DOC17/185201-21

**Re SSD 6619**

I refer to your electronic mail dated 1 August 2018 to the Environment Protection Authority (EPA) requesting our comments on the State Signification Development application submitted to the Department of Planning and Environment proposing the expansion of the existing Enirgi Power Storage Recycling Pty Ltd's used lead acid battery recycling facility located at Bomen near Wagga Wagga.

Figure 2-2: Enirgi Power Storage Recycling Facility Layout

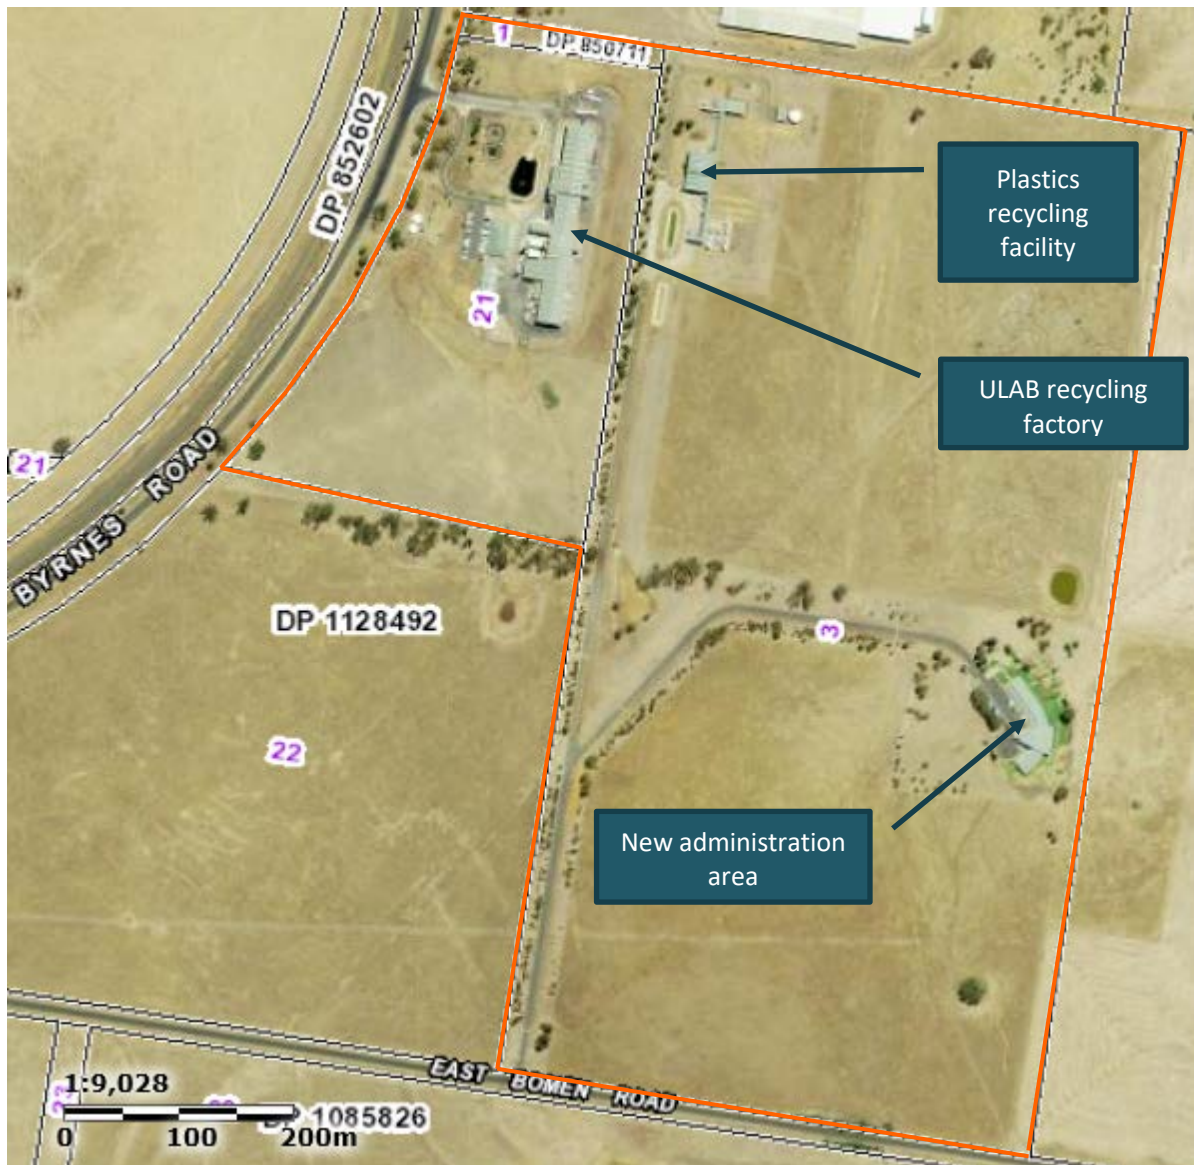
Figure 2-2 of the assessment identifies six (6) residential receptors and one (1) industrial receptor (located to the north of the existing site). However, the assessment only presents tabulated predicted ground level concentrations for the identified residential receptors at Table 6-1 and Table 6-2. Additionally, there appears to be receptors located to the south west, and a receptor directly to the south east of the site.

The assessment should present tabulated ground level concentrations for each receptor, including industrial/commercial receptors.

**Recommendation: Predicted ground level concentrations be tabulated and presented for all identified receptors, including identified industrial/commercial receptors and other identified receptors at the south east and south west.**
